Recommendation Report for Planning Permission for Works or Extension to a Dwelling

REF NO: AW/335/19/HH

LOCATION: 18 Gunwin Court
Aldwick
PO21 4BW

PROPOSAL: Single storey rear extension and construction of larger garage.

Proposed Roof Plan Scale 1:50

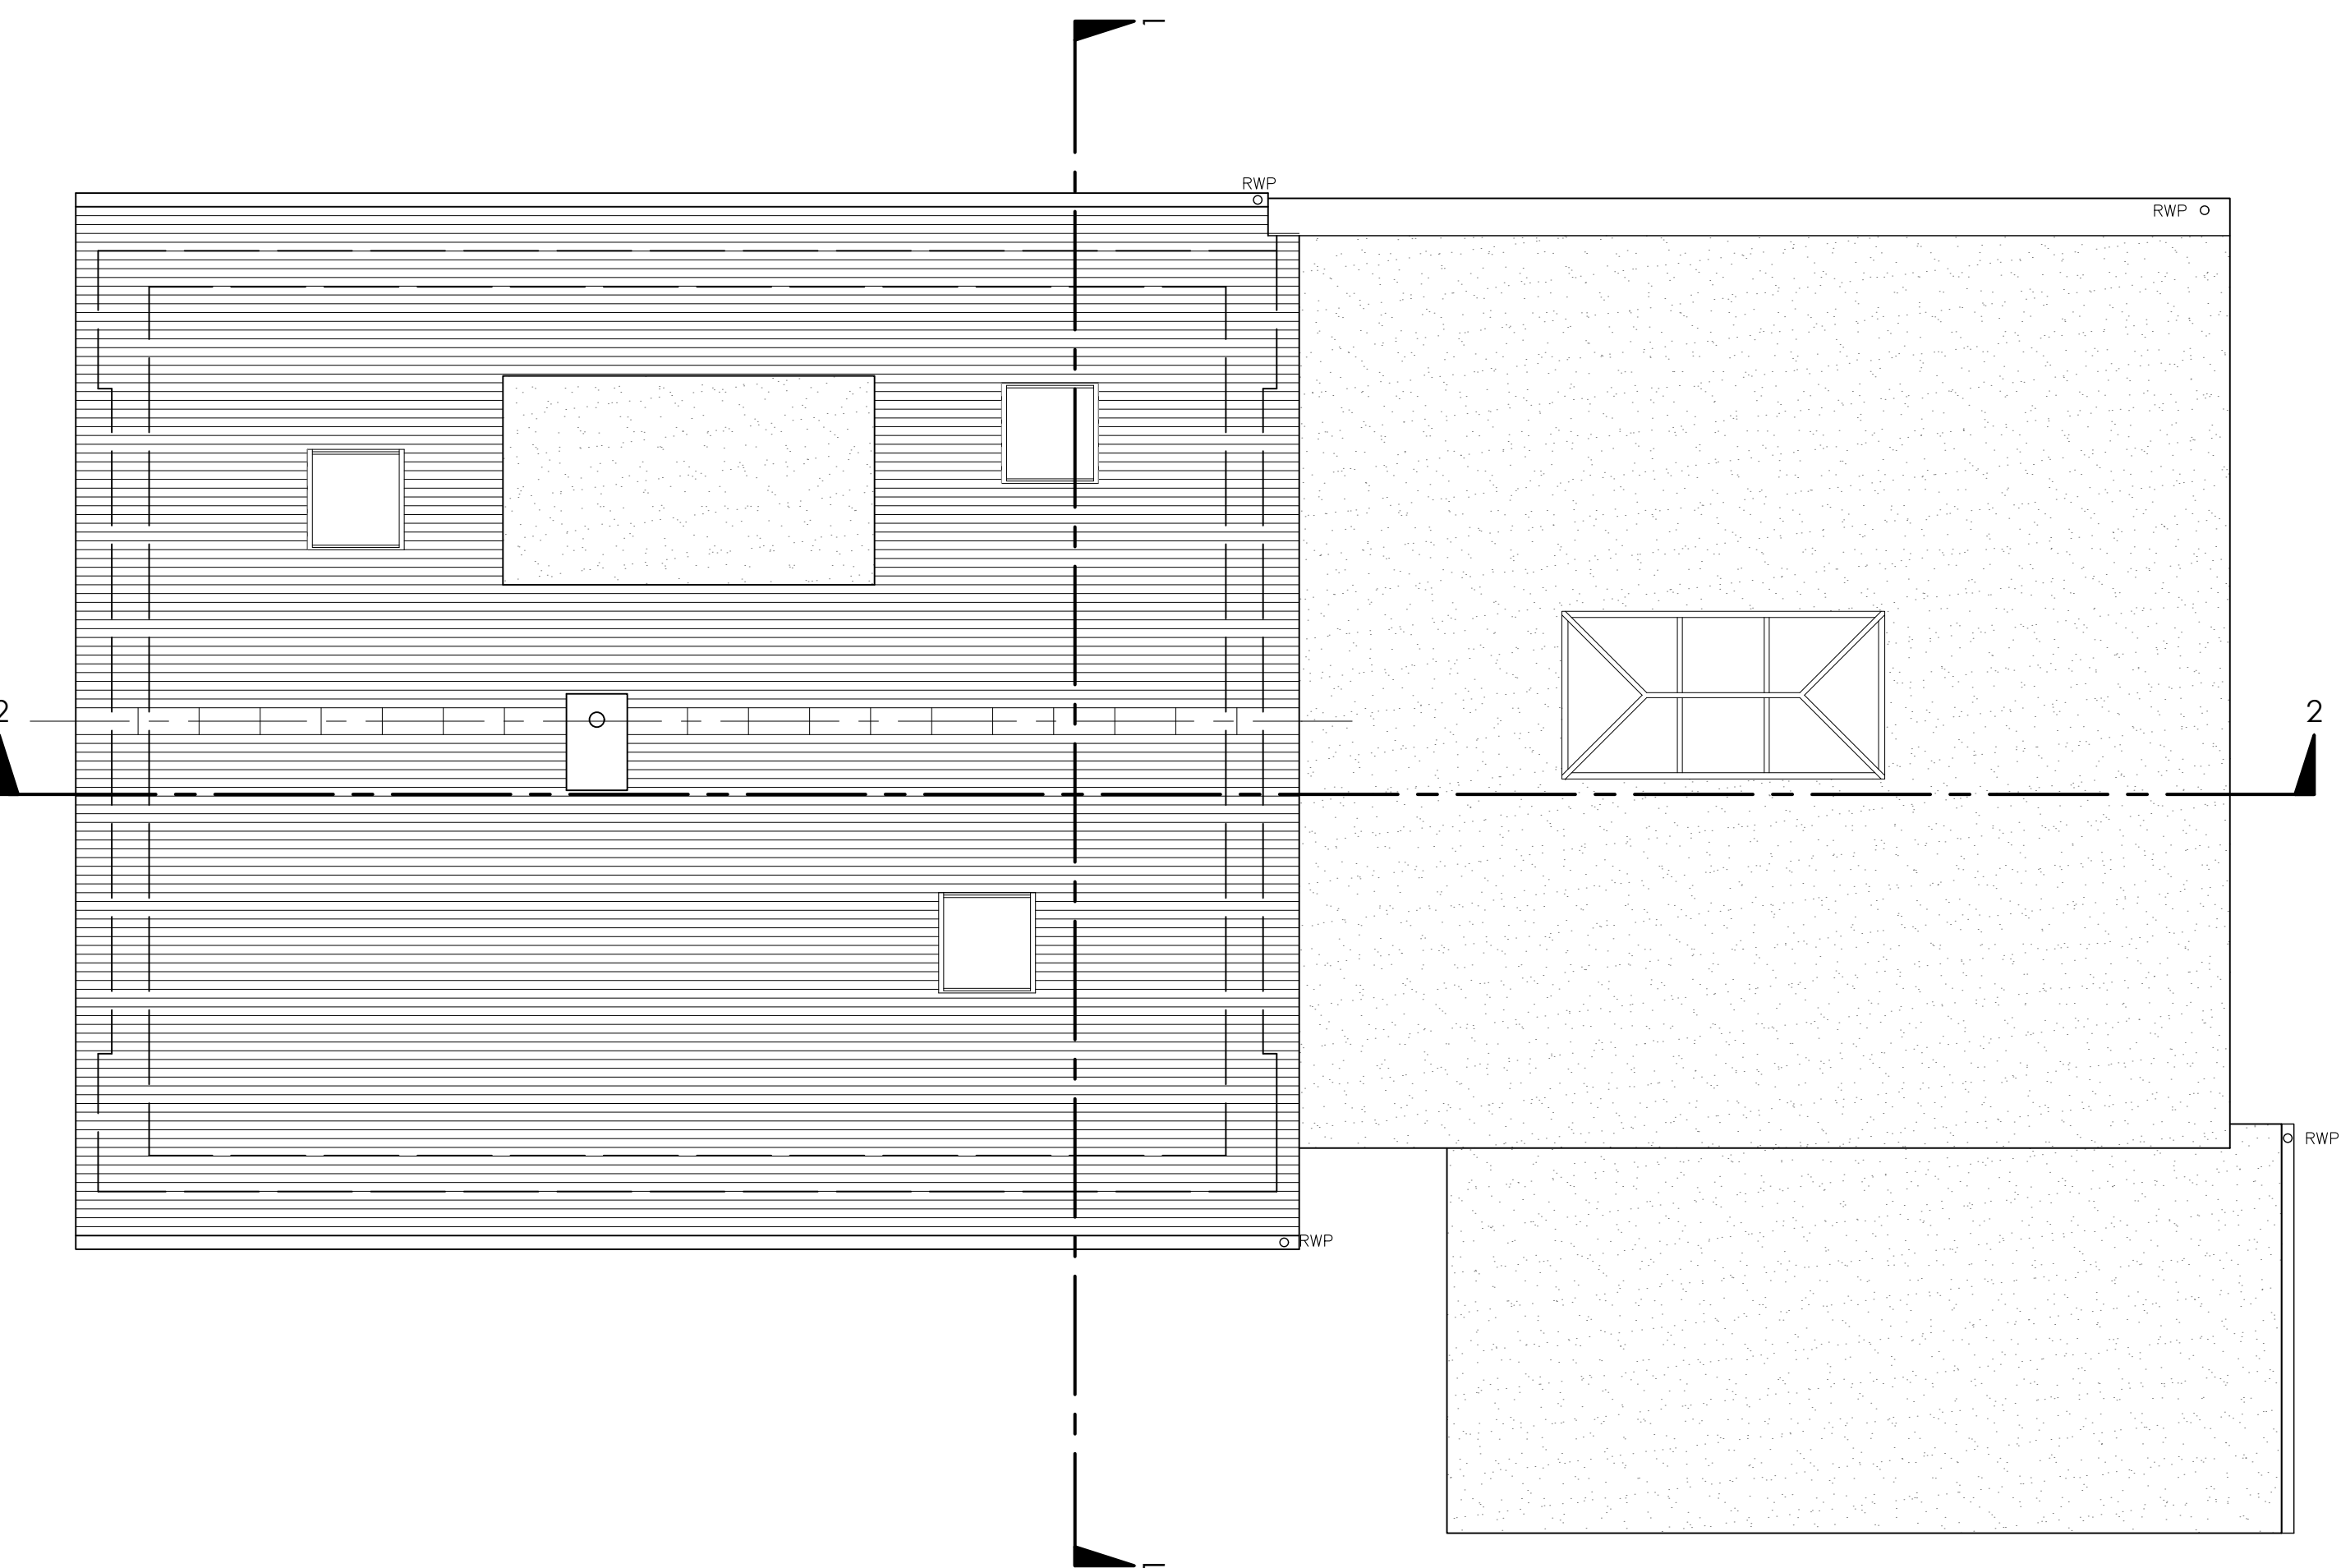
The proposal will extend from the north west rear elevation with a depth of 7.65m and run the full width of the property. It will have flat roof with a height of approximately 3.15m and 3.5m with roof lantern.

There is an existing garage which will be slightly enlarged with its depth increasing around 1m to 6.7m towards the front elevation of the property. The height will increase around 0.1m to 2.4m. The garage will remain largely the same as existing and runs along the boundary to the north west. The garage attaches to the proposed extension.

| Drawing title | Proposed Elevations                                                      |  |  |

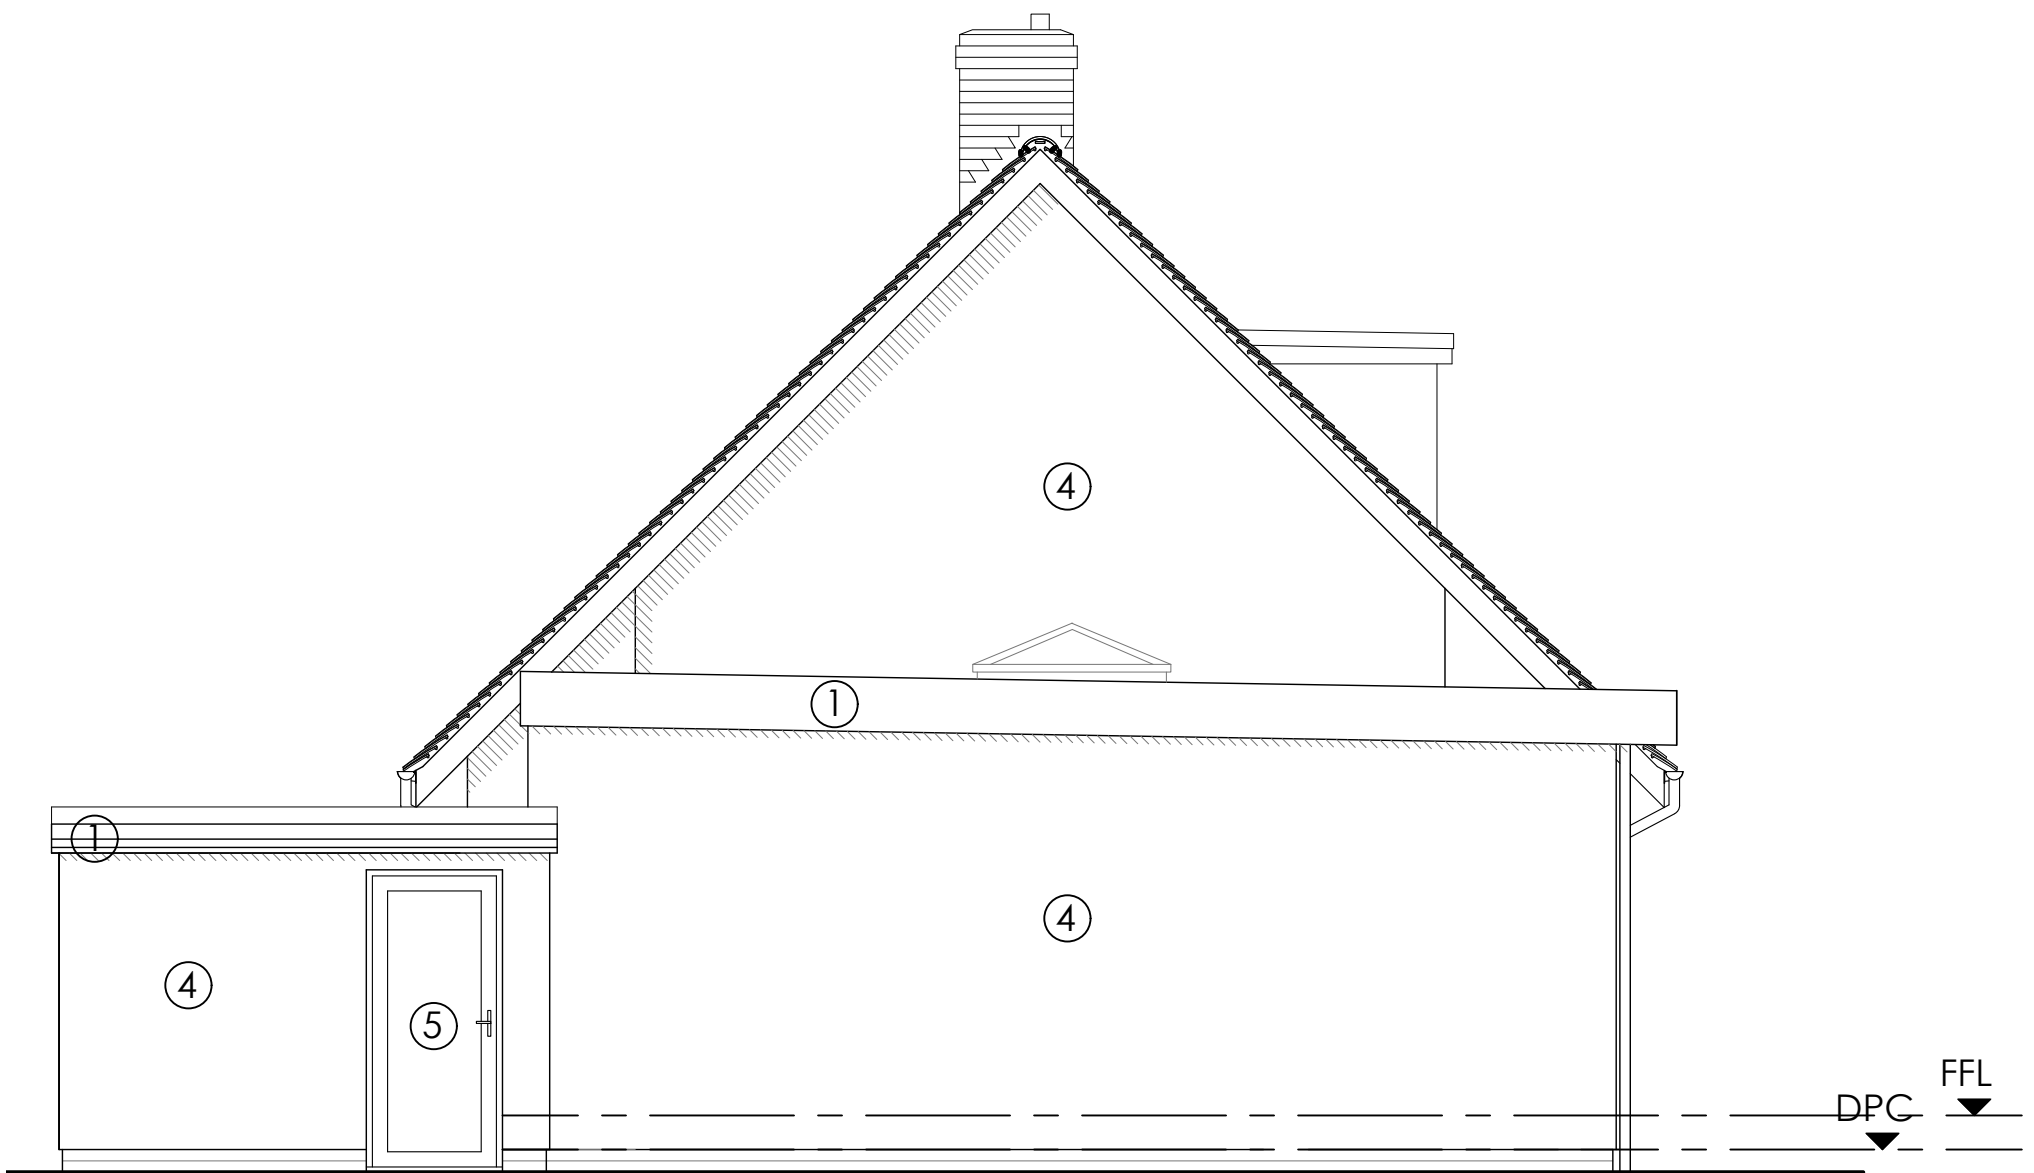
The extension is large in depth however is considered subservient to the host dwelling due to the modest height. As a result of its siting to the rear, is also not considered to appear unduly dominant upon the surrounding area. The development retains sufficient garden space and is not considered an overdevelopment of the site.

Whilst large in depth, at a modest height and with the bulk of the extension 3m from the boundary fencing, the development is not considered to appear adversely overbearing or overshadowing upon amenity. The development is not considered to give rise to adverse overlooking with 2 sets of doors to the south western elevation with 23m retained to the boundary. There will be 2 additional velux however with a dormer already in existence views are not considered to increase significantly from that which is already achievable.

Drawing title
Proposed Site Plan / Block Plan

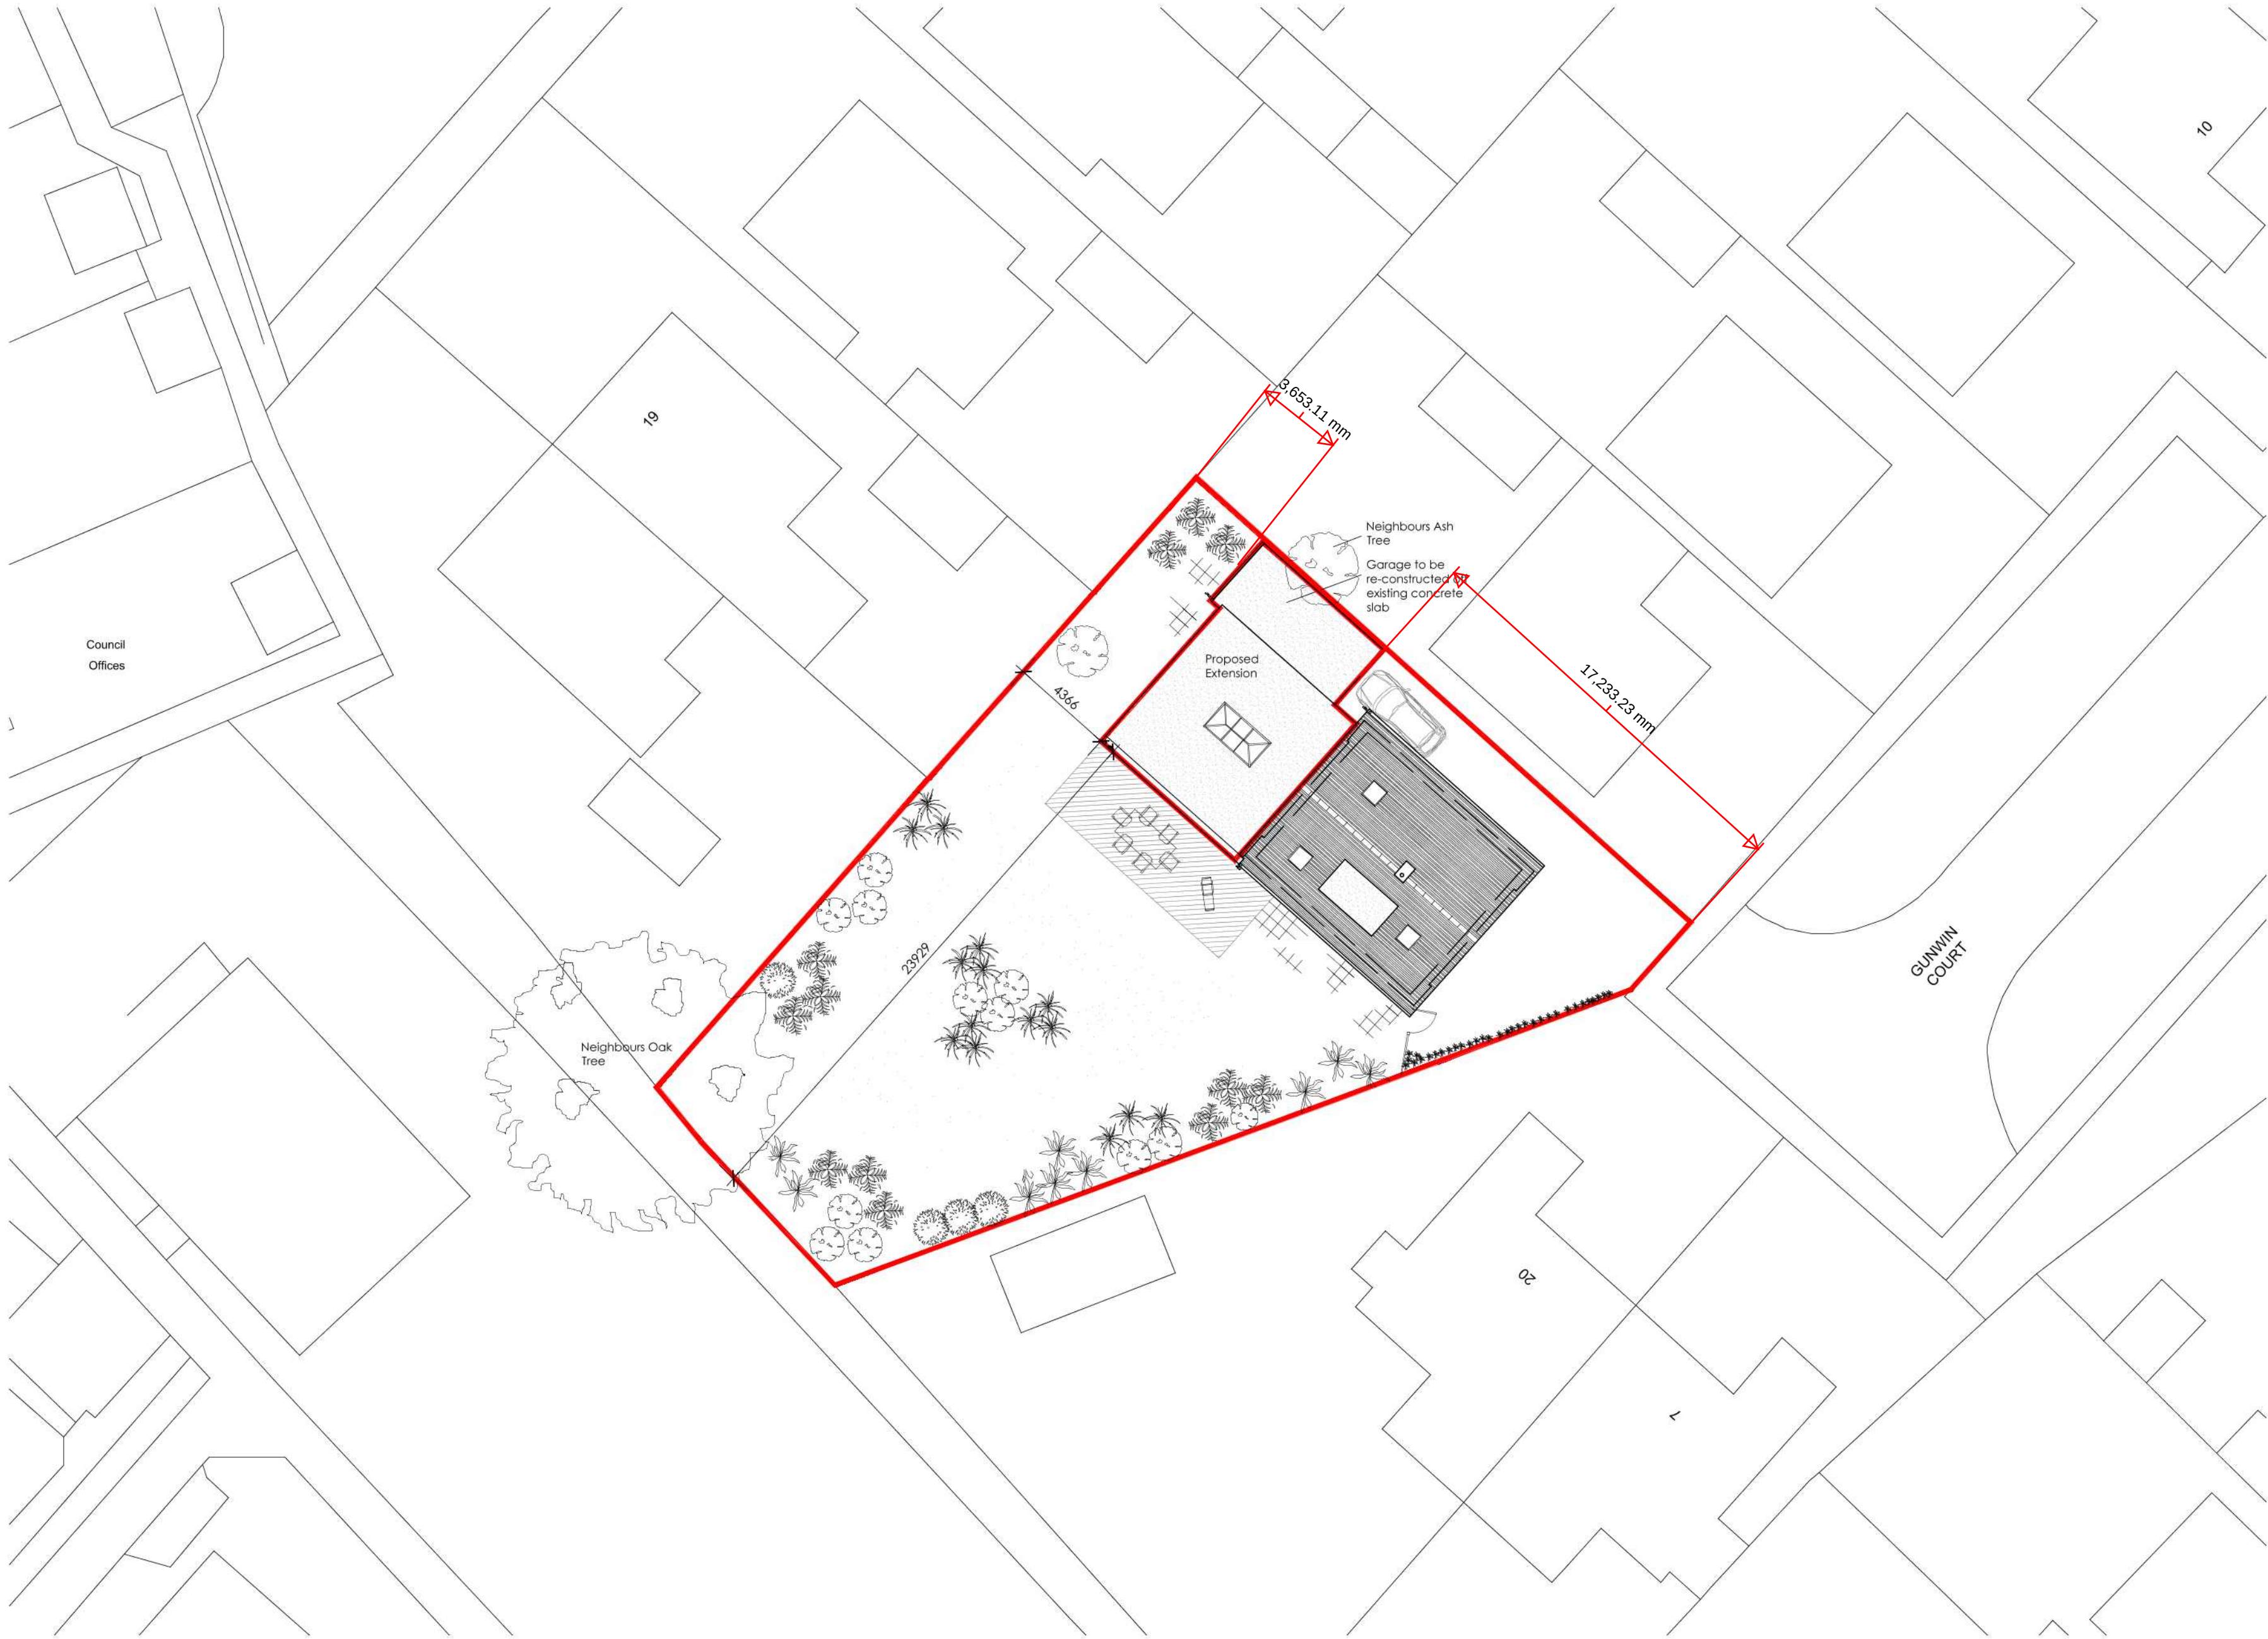
The Council uses a 45 degree rule to assess serious effects on neighbouring properties. The existing garage already intersects a 45 degree angle when drawn from the centre of the ground floor rear window at the neighbouring property at No. 16 and with the extension situated behind this, it is not considered the addition would be significantly harmful to the amenity of the adjoining occupiers to the east. An extension could be constructed up to this depth with prior approval and with no representation received, the development is considered acceptable.
